**WELWYN HATFIELD BOROUGH COUNCIL
EXECUTIVE DIRECTOR - PLANNING, PUBLIC PROTECTION AND GOVERNANCE**

DELEGATED APPLICATION

Application No: 6/2019/2313/FULL
Location: 101 Brookmans Avenue, Brookmans Park, Hatfield, AL9 7QG
Proposal: Erection of six dwellings following demolition of existing buildings
Officer: Mr David Elmore

Drawing Title
 TYPICAL CROWN ROOF DETAILS

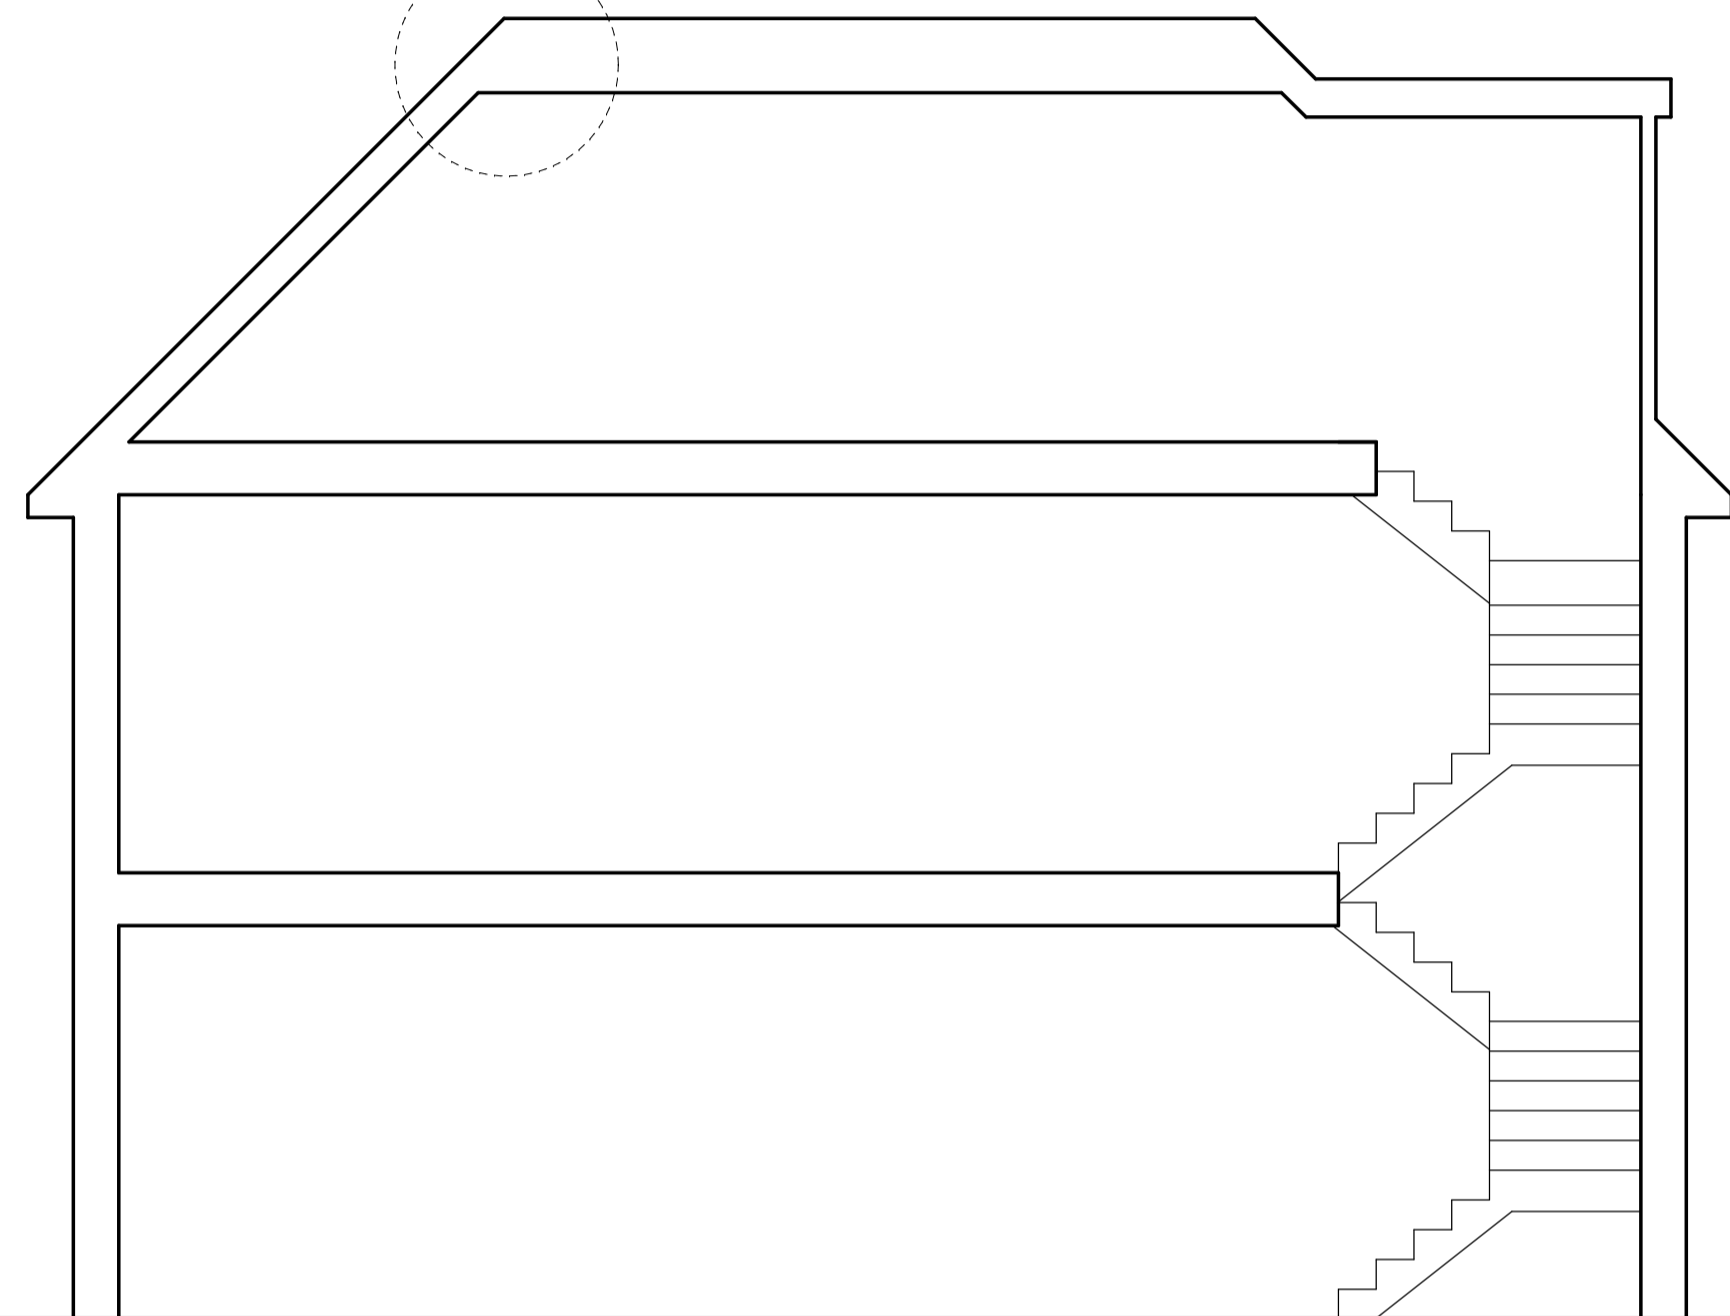
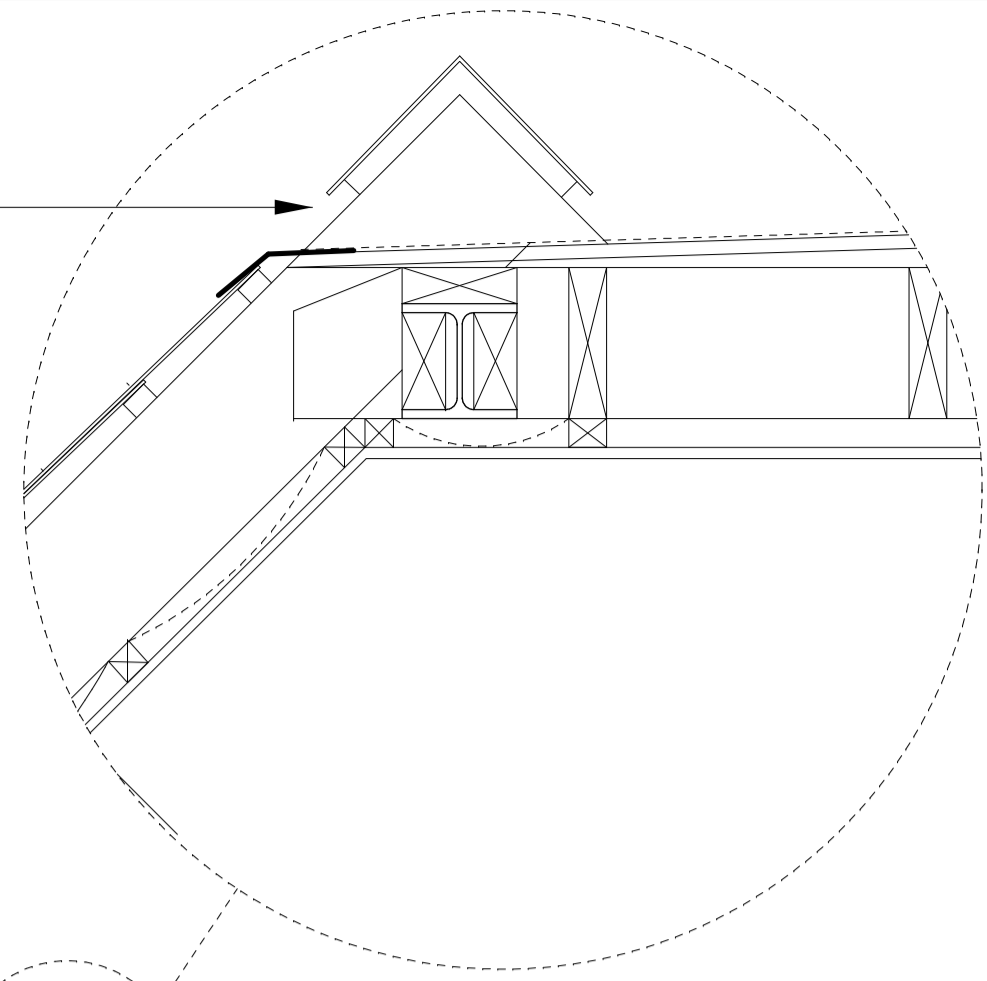
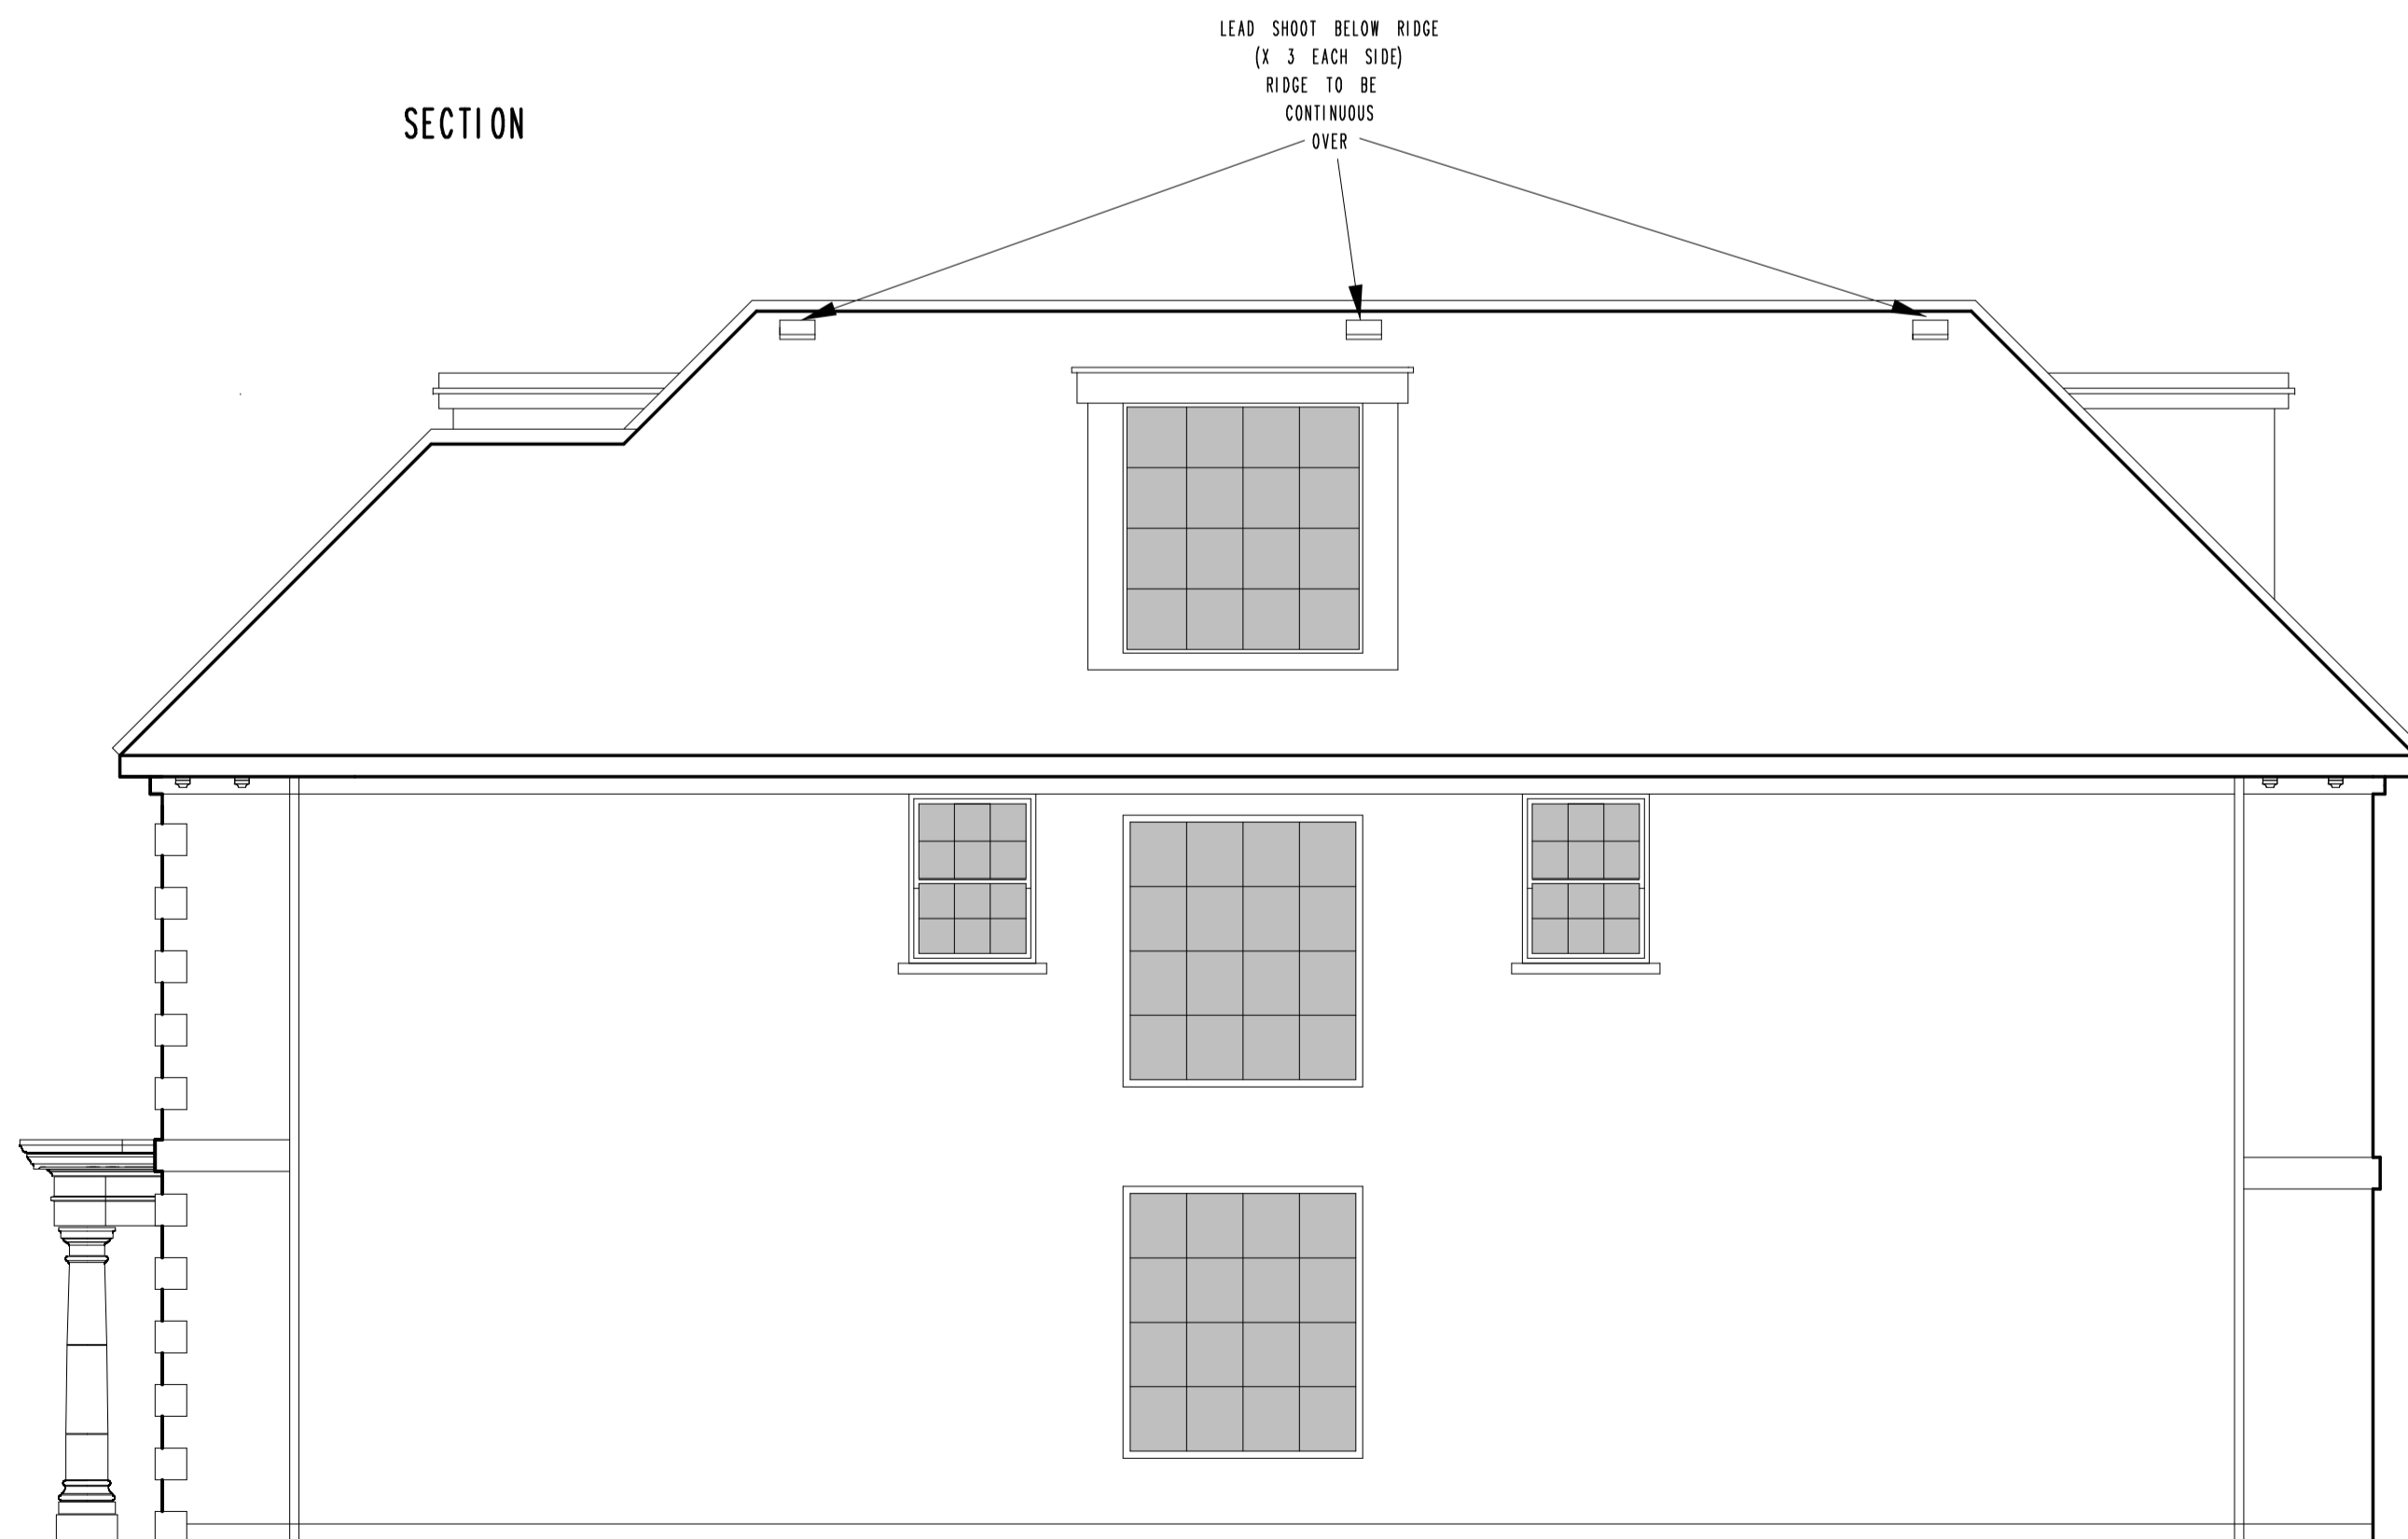
A drawing showing crown roof detailing has been submitted with this application. However, these details do not clearly show that the flat roof would be stepped down behind the surrounding pitched roof, nor does the drawing state that such detailing would be applied to each of the 6no dwellings proposed. Amended details can be secured through a planning condition.

1. Notwithstanding submitted drawing number: 48 5018-26, relating to crown roof details, no development above ground level shall take place until amended details of the proposed crown roof have been submitted to and approved in writing by the Local Planning Authority. The details, including; a roof plan, elevations and sections, in either 1:50 or 1:100 scale, and applying to all dwellings, must clearly show that the flat roof is stepped down and concealed behind the surrounding pitched roof. The pitched roof must use ridge tiles. Subsequently the development must be carried out in accordance with the approved details.
